Our Ref: BR/109/18/PL
Your Ref:

Town & Country Planning Act 1990 (as amended)
Town and Country Planning (Development Management Procedure) (England) Order 2015
Application for Planning Permission

Development Conversion of first & second floors & alterations to create additional third floor containing 5 No. self-contained flats.
Location 37A London Road Bognor Regis

Rear Bin and Bicycle Storage

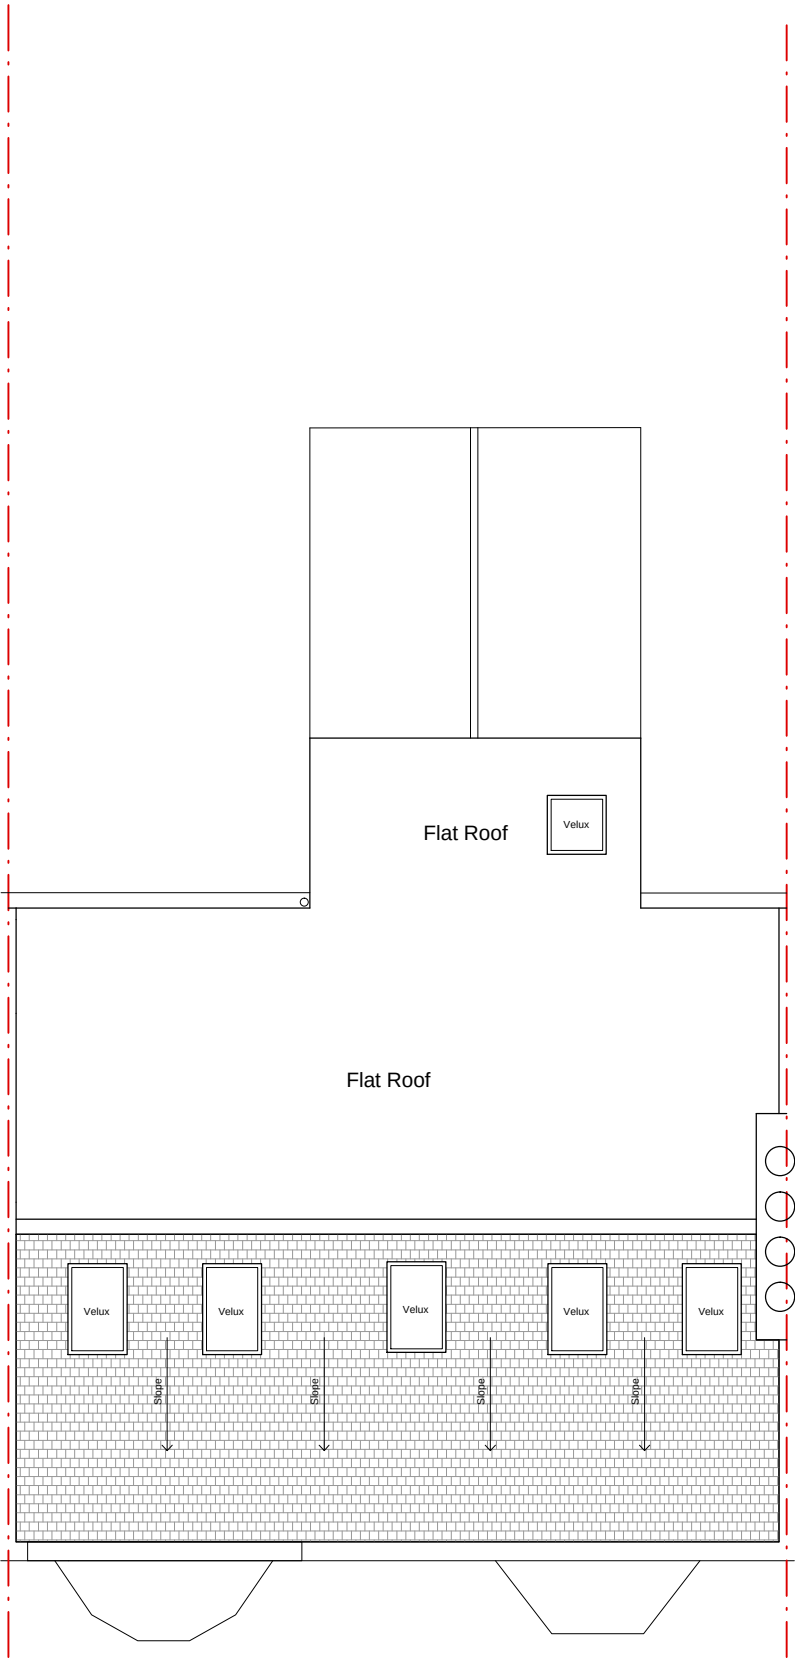
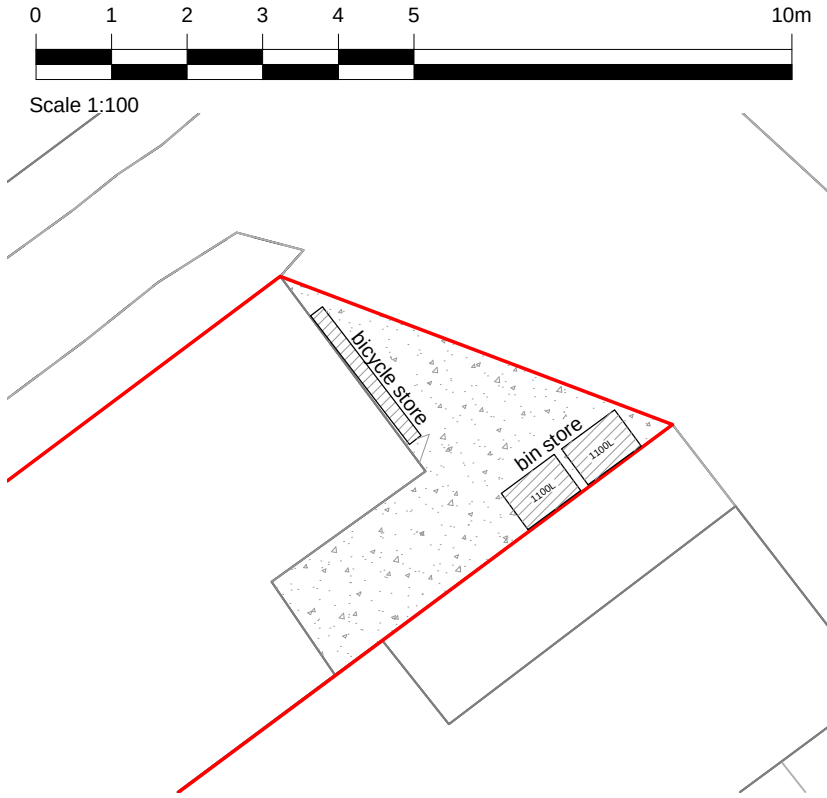
Please provide floor plans and elevations for the proposed bicycle store & bin store.

Drawing
Proposed Side Elevation

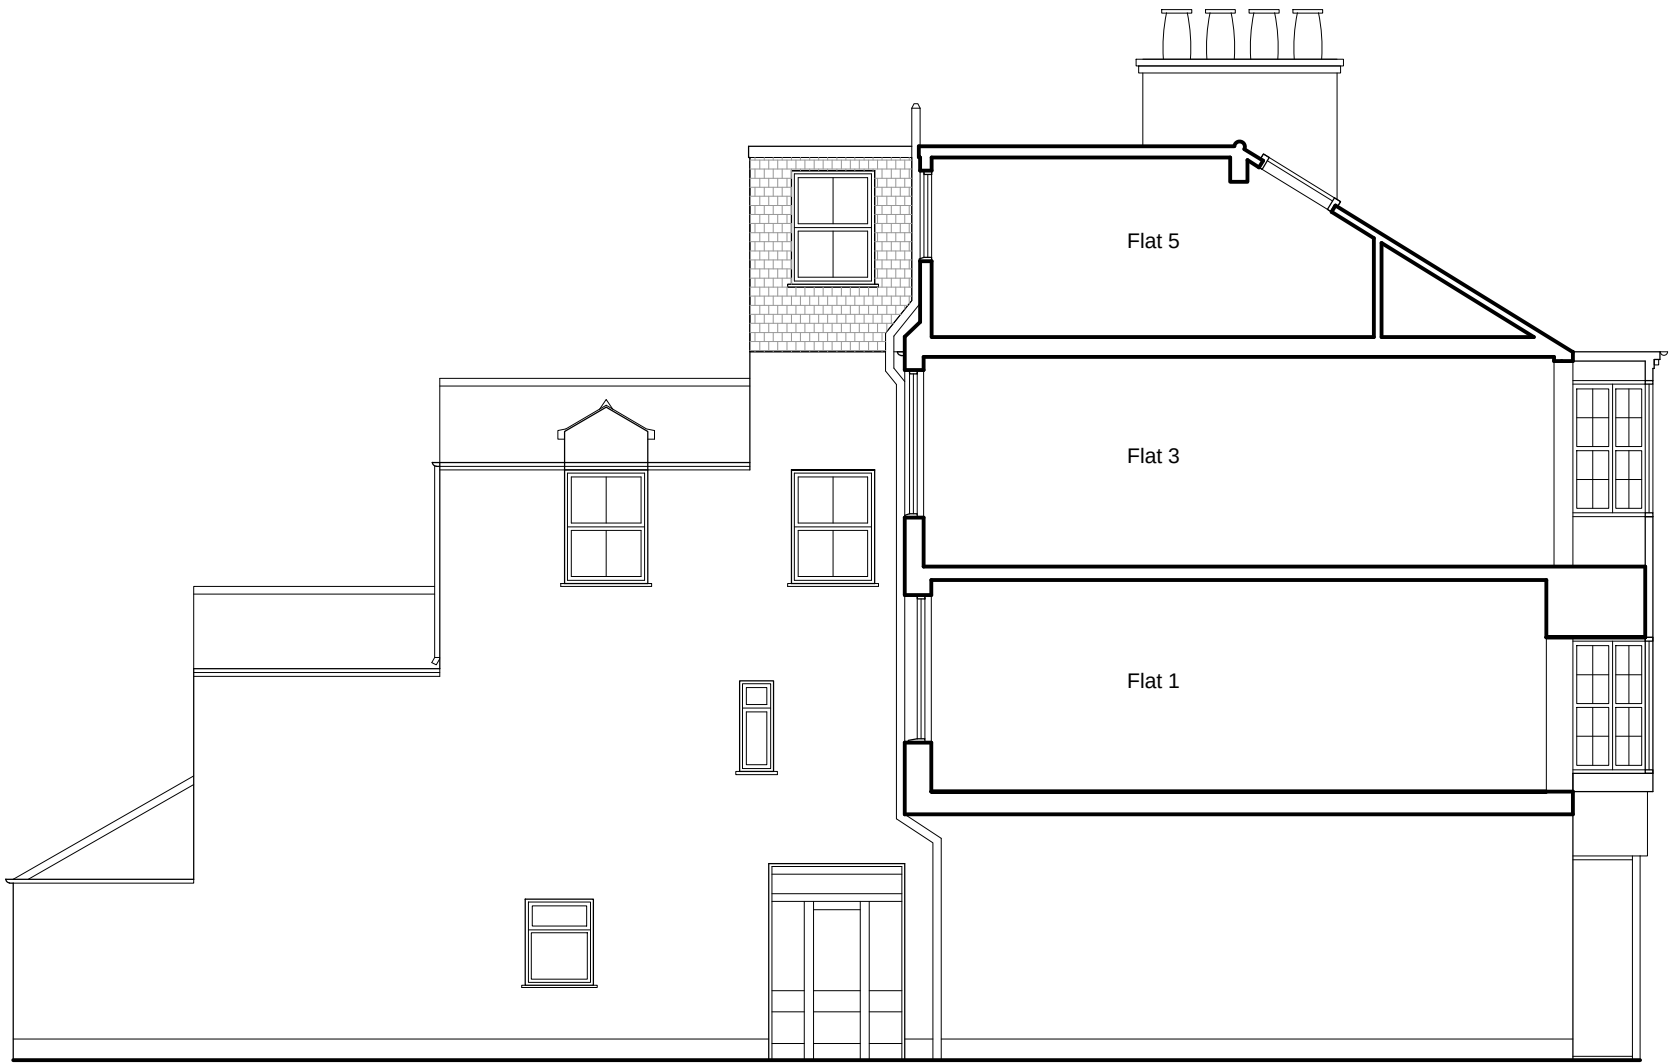
The existing and proposed side elevations and existing and proposed first floor plans do not accord. Please amend accordingly.

Block plan
1:500

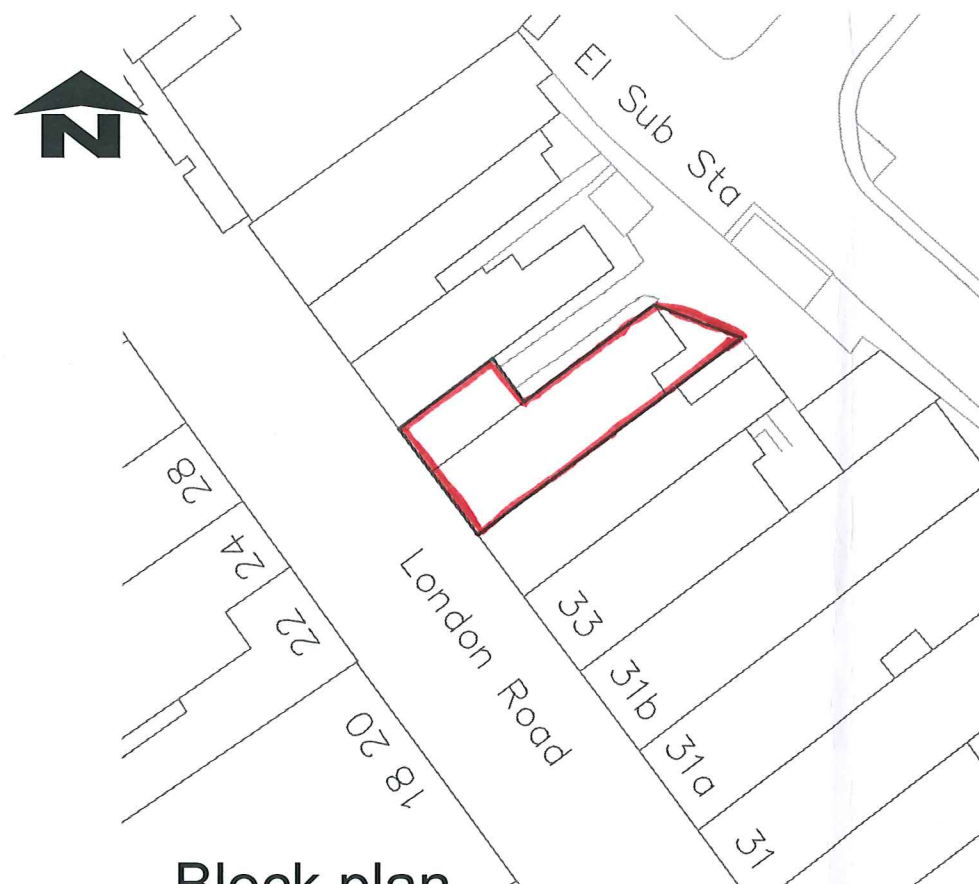
Block Plan

Please submit 1 electronic or 3 paper copies of a block/site plan at a scale of 1:500 or 1:200. Further details of what must be included on the plan can be found in the National Validation Requirements.
